Project # 1006882

Project Name: SANTA FE ADDITION

**CITY OF ALBUQUERQUE
PLANNING DEPARTMENT
March 19, 2008
DRB Comments**

RE: Lots 11 & 12, Block 4, Santa Fe Addition

**PLAT OF
LOTS 11-A AND 12-A
BLOCK 4
SANTA FE ADDITION**

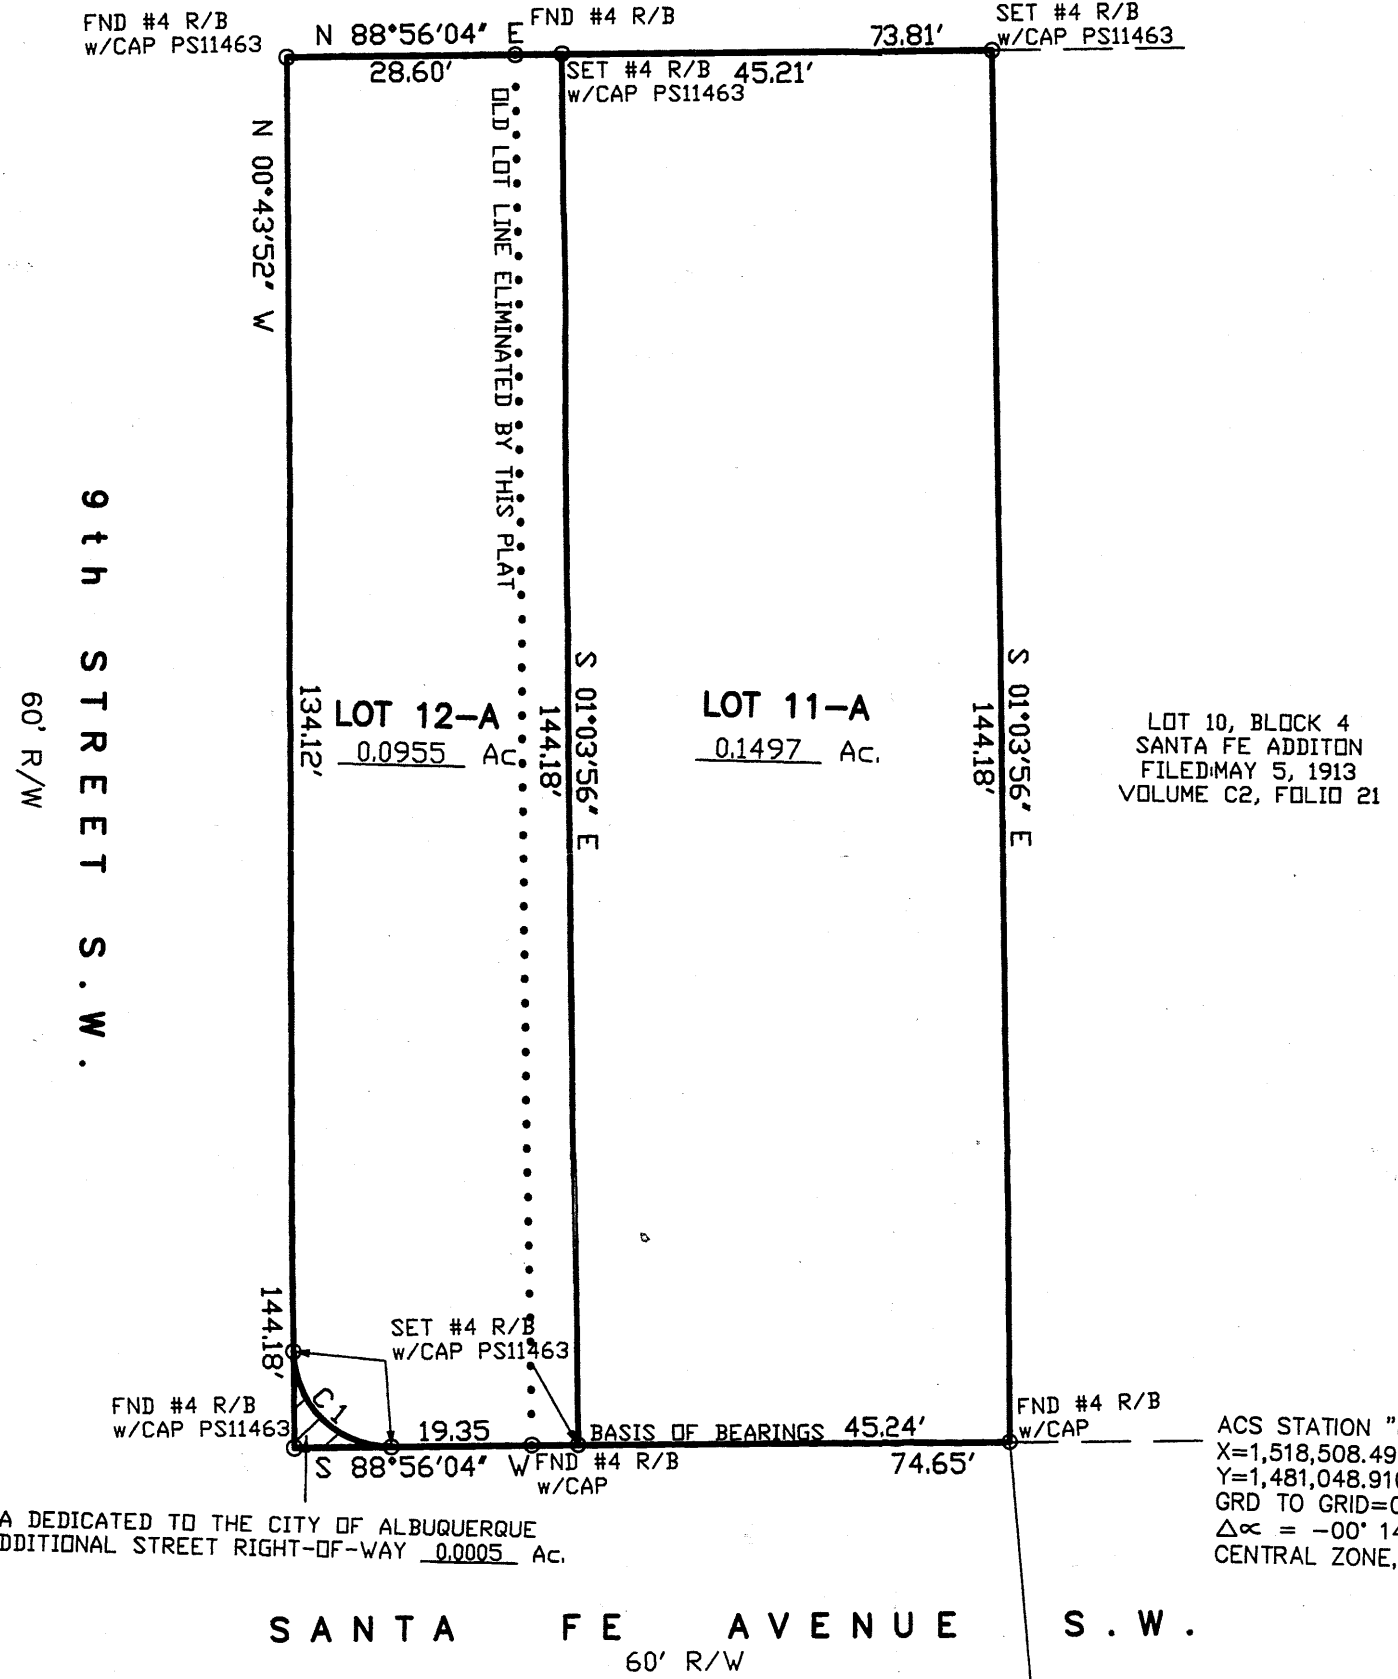
TRANSPORTATION: - verify / improve
- 20' reduction

PLANNING (Last to sign): - Utility re-location
5/28/08 - Utilities signature

The overhead service line to the existing house on Lot 11 must be re-located or an easement must be provided over new Lot 12-A.
